WEST SUSSEX COUNTY COUNCIL CONSULTATION

TO:	Arun District Council FAO: Maria Tomalova
FROM:	WSCC - Highways Authority
DATE:	28 April 2020
LOCATION:	1 Avisford Terrace, Rose Green Road, Aldwick, PO21 3HB
SUBJECT:	AW/98/20/PL Construction of a single storey office extension to the rear of the property, including the removal of the existing store room. Works will also include the replacement of the existing shop front and dwarf walls with fully glazed aluminium windows and doors. Retail area to be used as showroom.
DATE OF SITE VISIT:	N/A
RECOMMENDATION:	Advice, Modification
S106 CONTRIBUTION TOTAL:	N/A

PROPOSED FLOOR PLAN

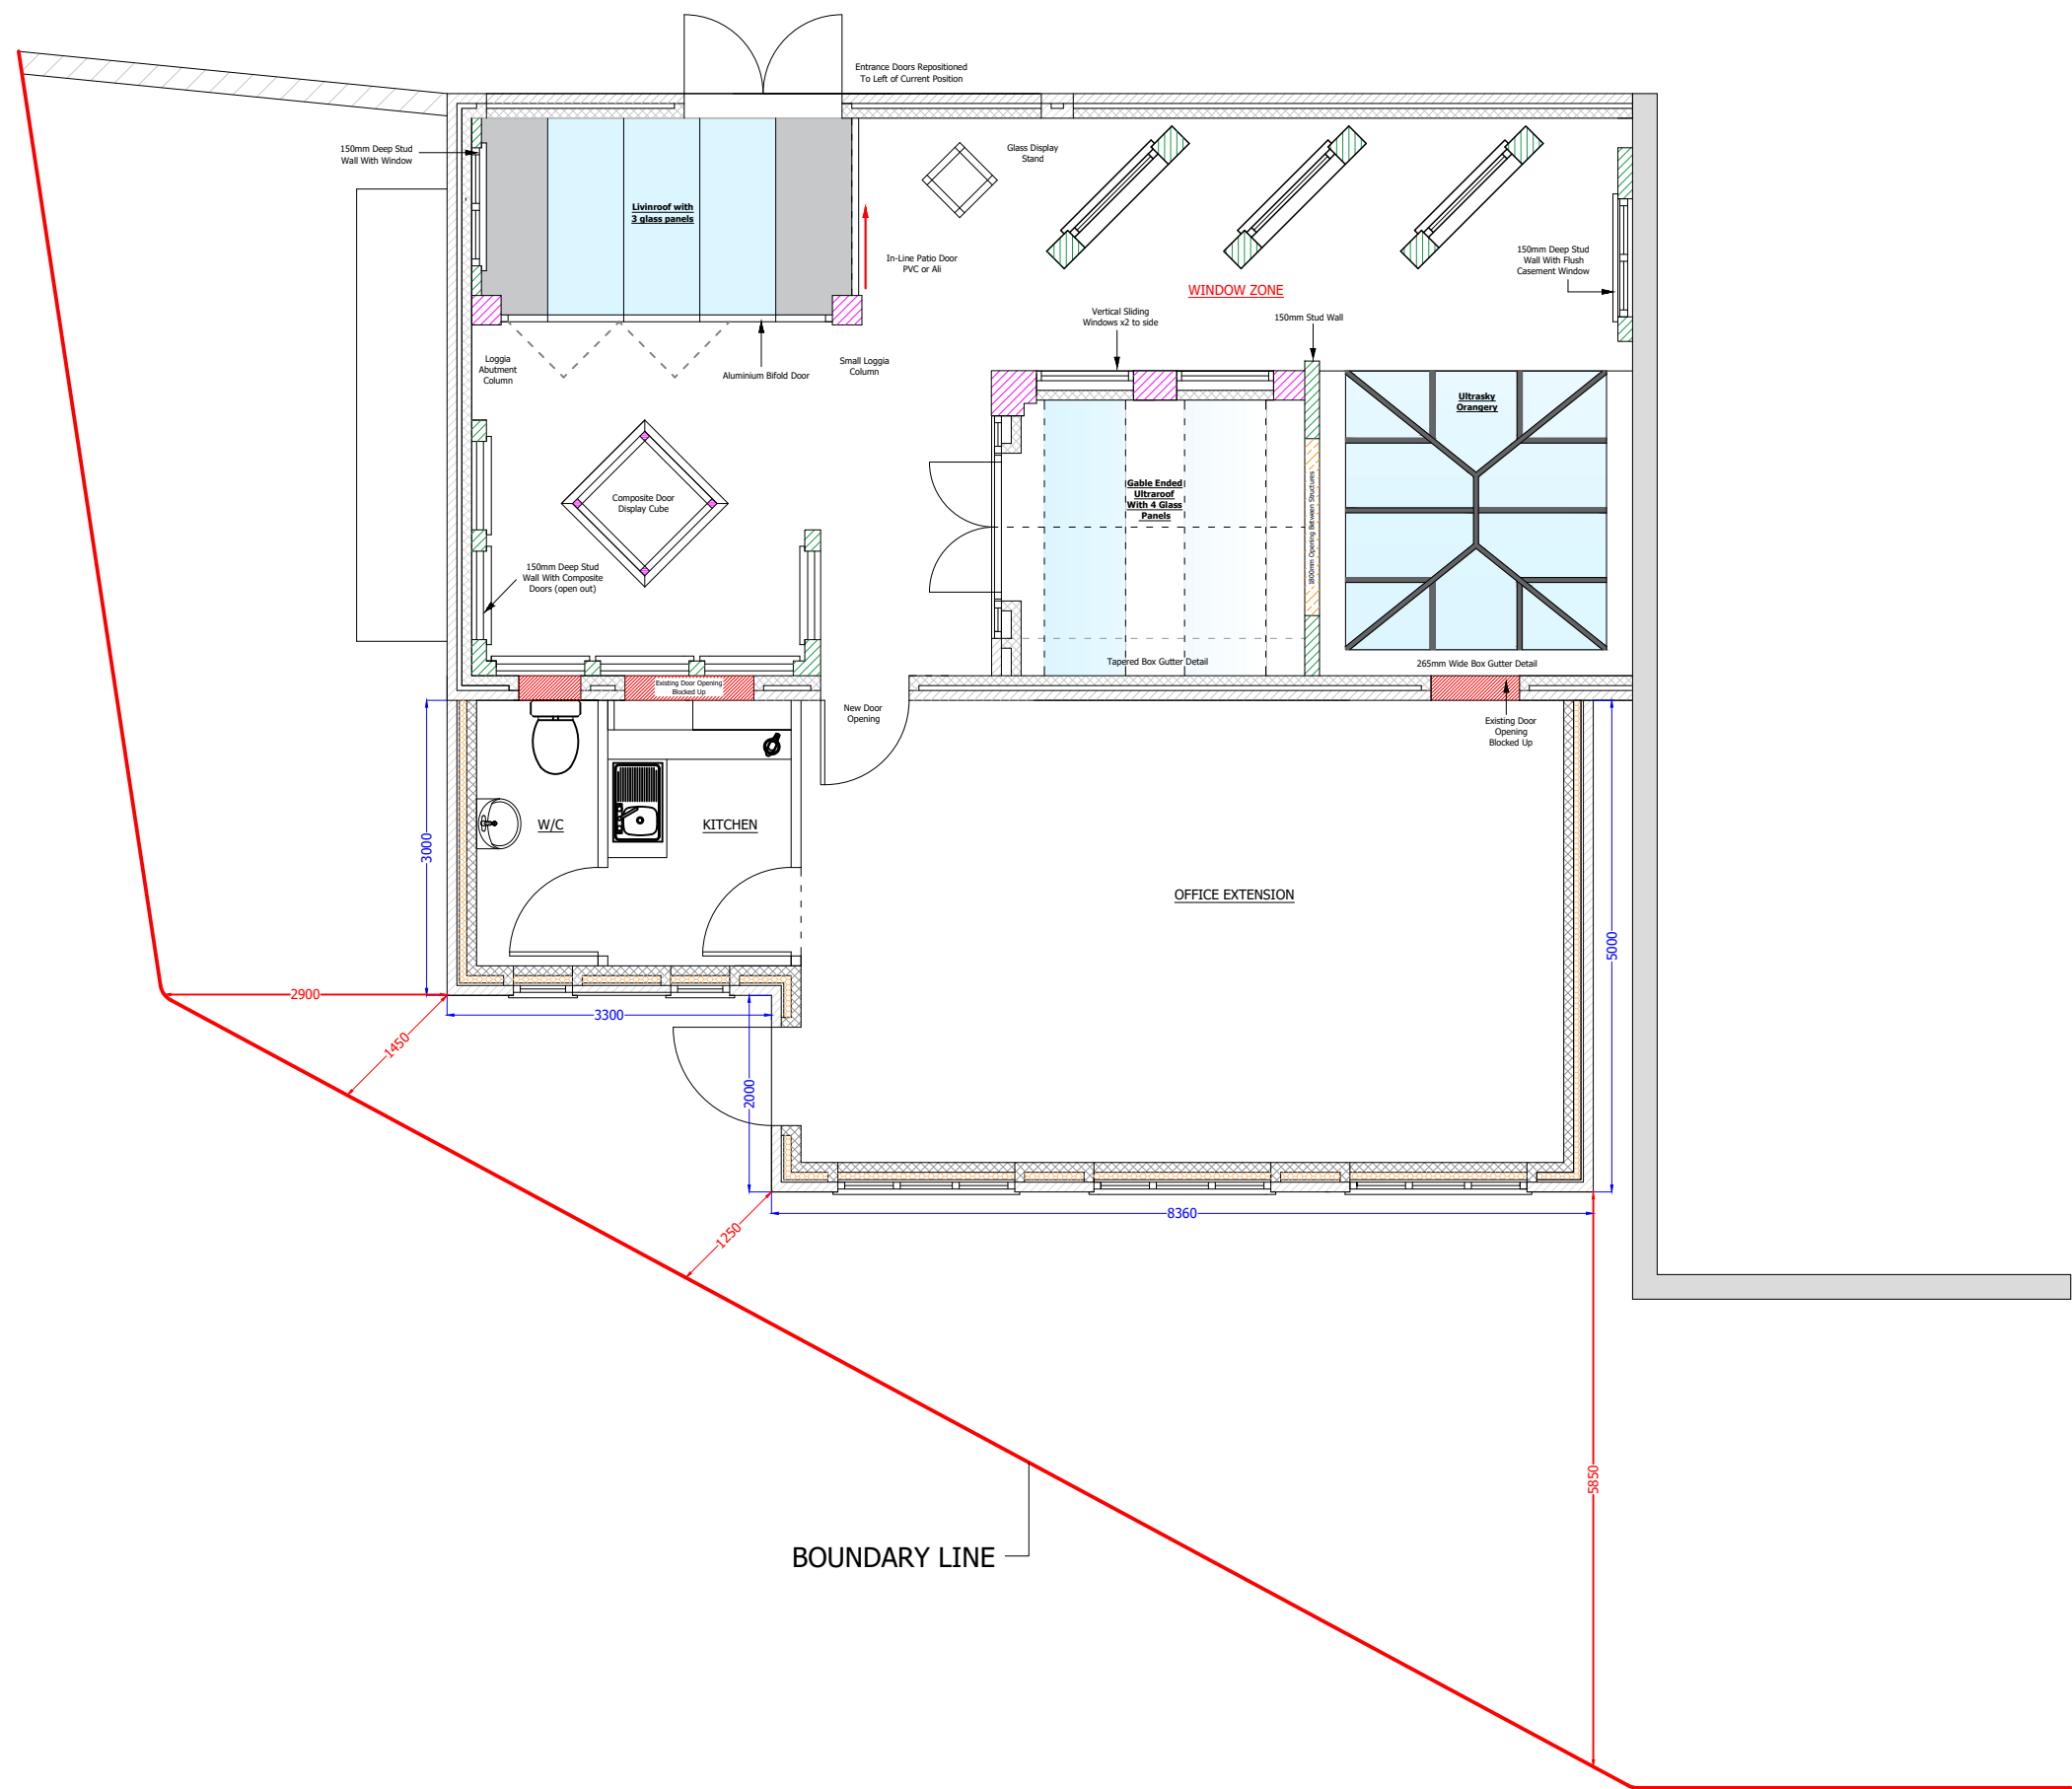
The plans indicate that the entrance doors will open outwards of the site, opening onto the publicly maintained highway, posing a form of obstruction. The applicant is advised to modify the proposed plans to demonstrate the doors opening inwards of the site. The applicant should be aware that obstructions within the public highway are liable to enforcement by the WSCC local area office.
